MARINE RESTORATION & CONSTRUCTION LLC

Property Owner: Mr. Kevin Dallas
4403 Forest Ave SE
Mercer Island, WA 98040

Re: ***SHL23-028; 4403 Forest Ave SE***

PROPOSED FRAMING PLAN

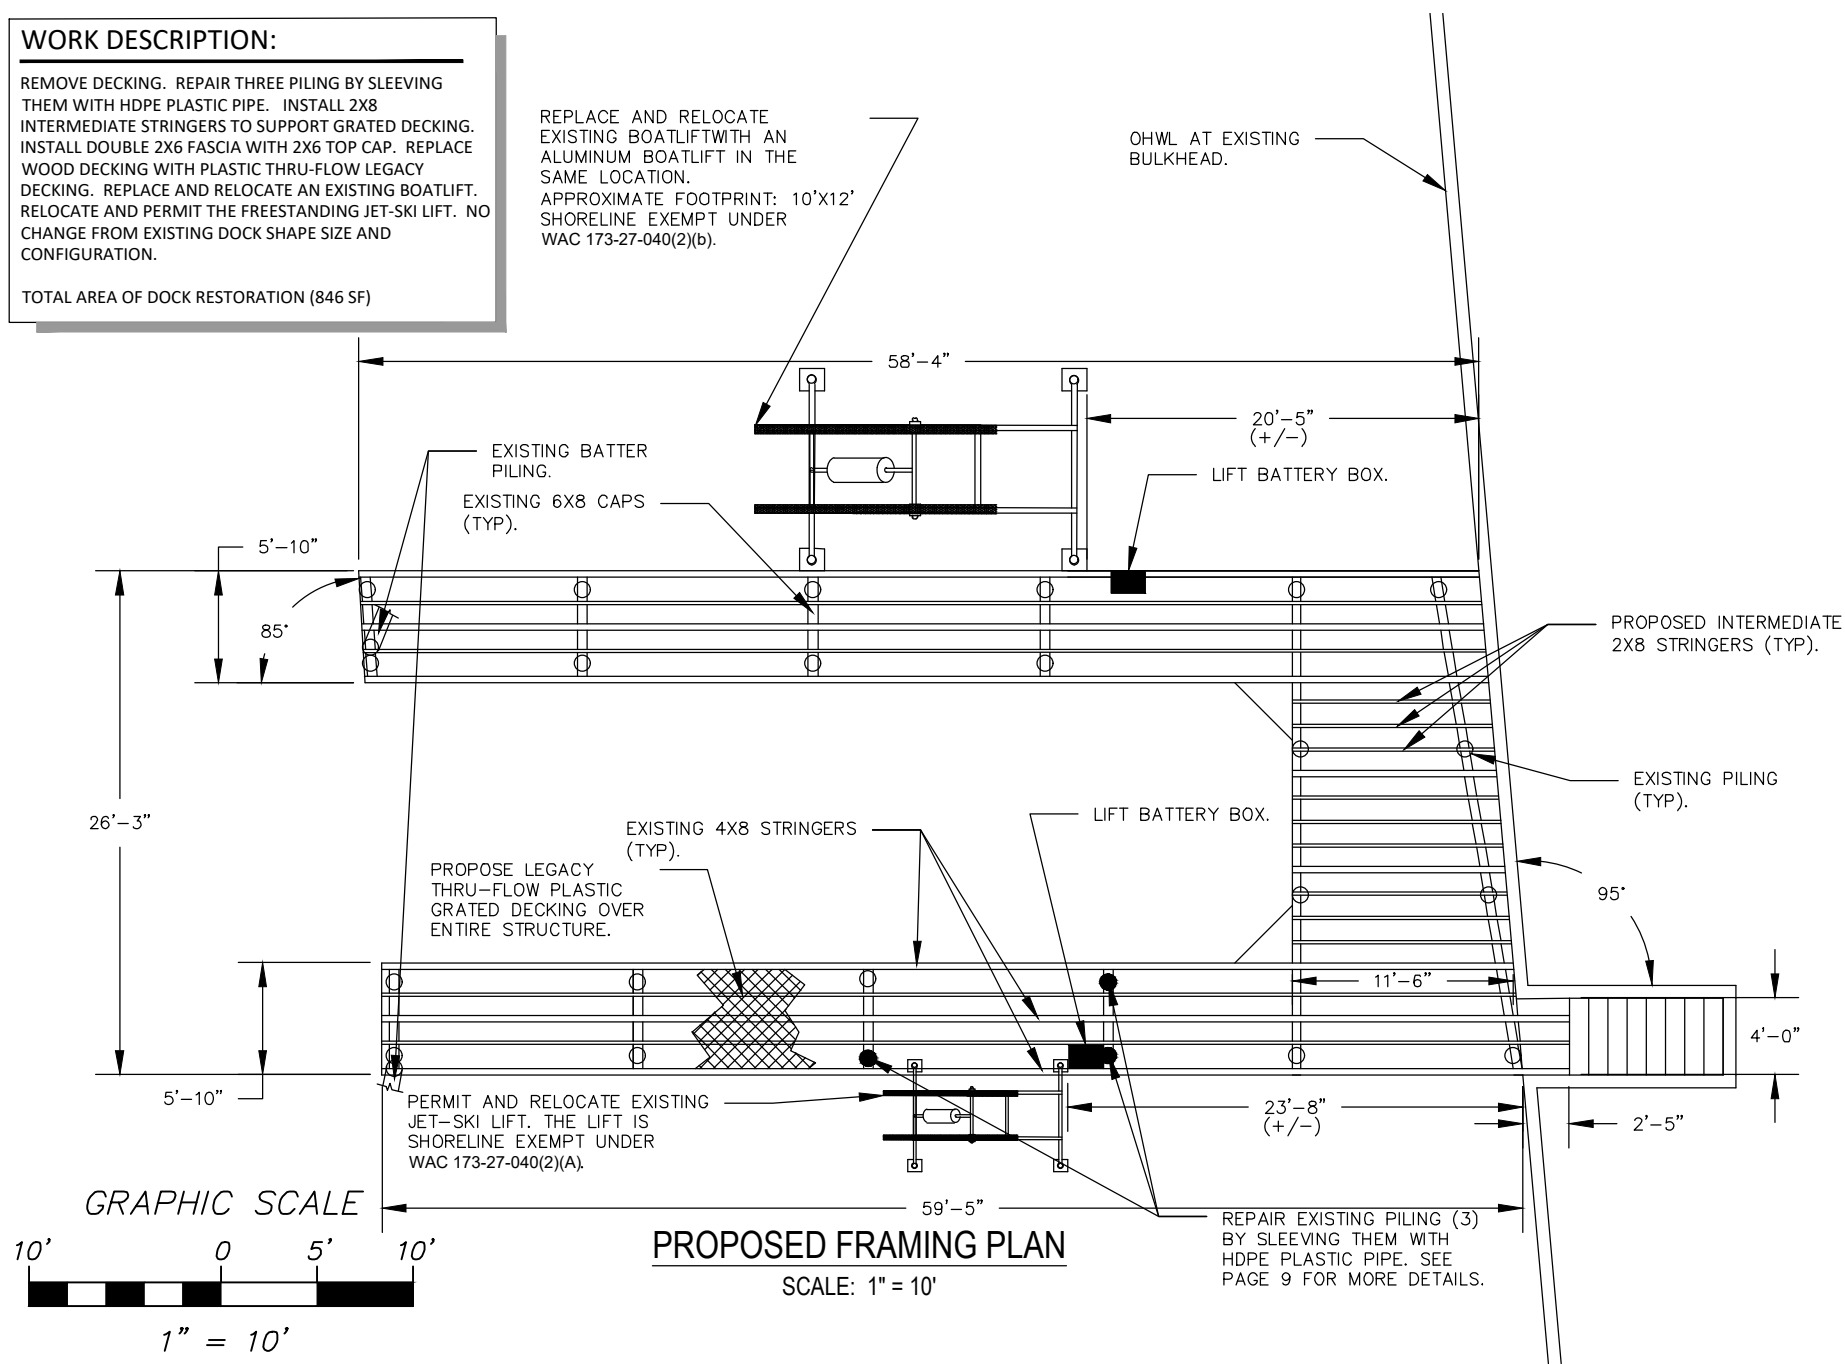
Please see the following statement we provide to answer, "*Provide existing permit for the jet-ski lift, or include the jet-ski lift in the scope of work to retroactively permit via a shoreline exemption or shoreline substantial development permit.*", from your email dated May 3, 2023.

We would like to proceed with retroactively permitting the jet-ski lift via a shoreline exemption. This is categorically exempt WAC 173-27-040(2)(a).

ADDENDUM A:
STRUCTURE SEPARTATION DETAIL
 SCALE: 1" = 30'

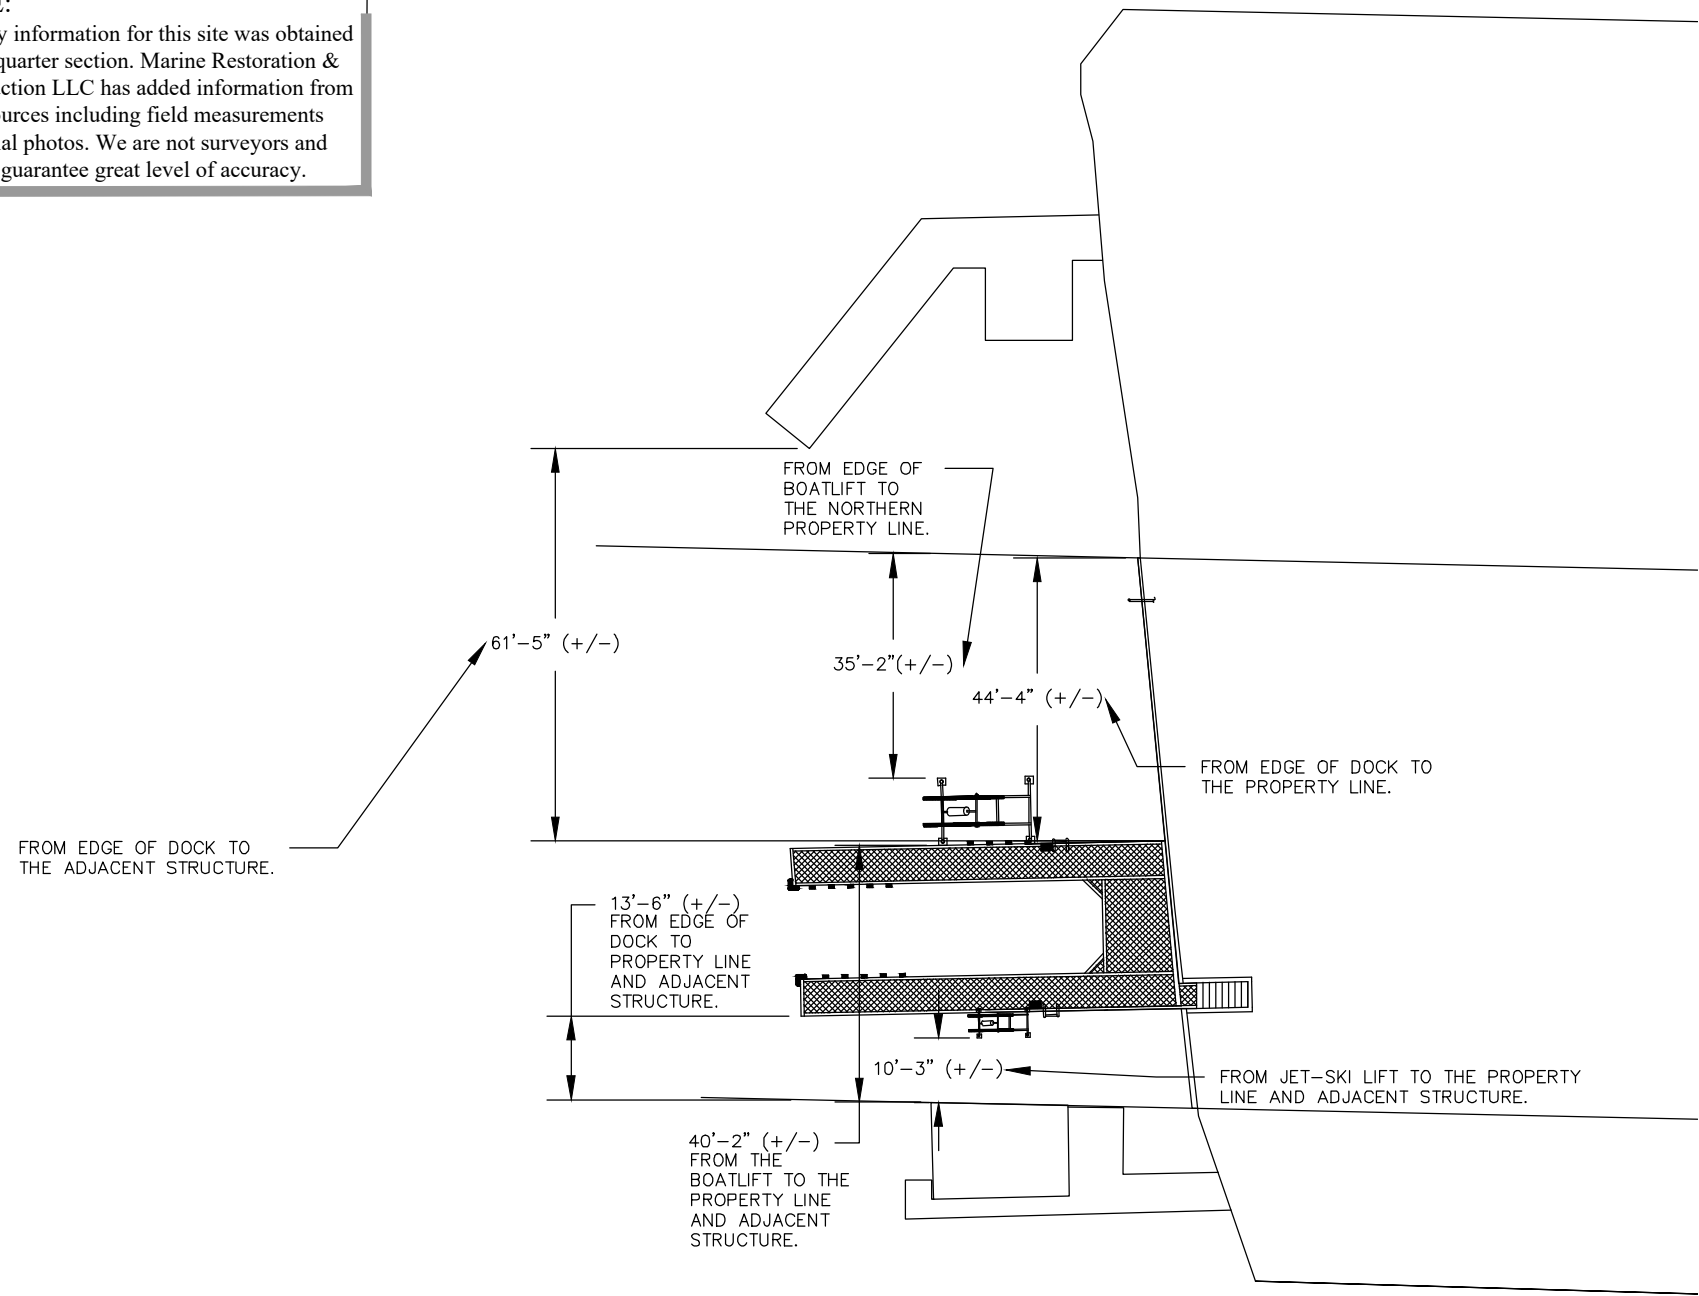
In order to address MICC 19.15.210(B), we would like permission to propose that we bring the site up to compliance with the original intended permit by placing a boatlift in the original permit location. This will be adhered to upon obtaining permission through our land use review process. A boatlift will be placed after July 16th when the in-water work window is open in the approved location. The location of the lift placed at this time will be 35' 1" from the adjacent property line and much further from any adjacent structure.
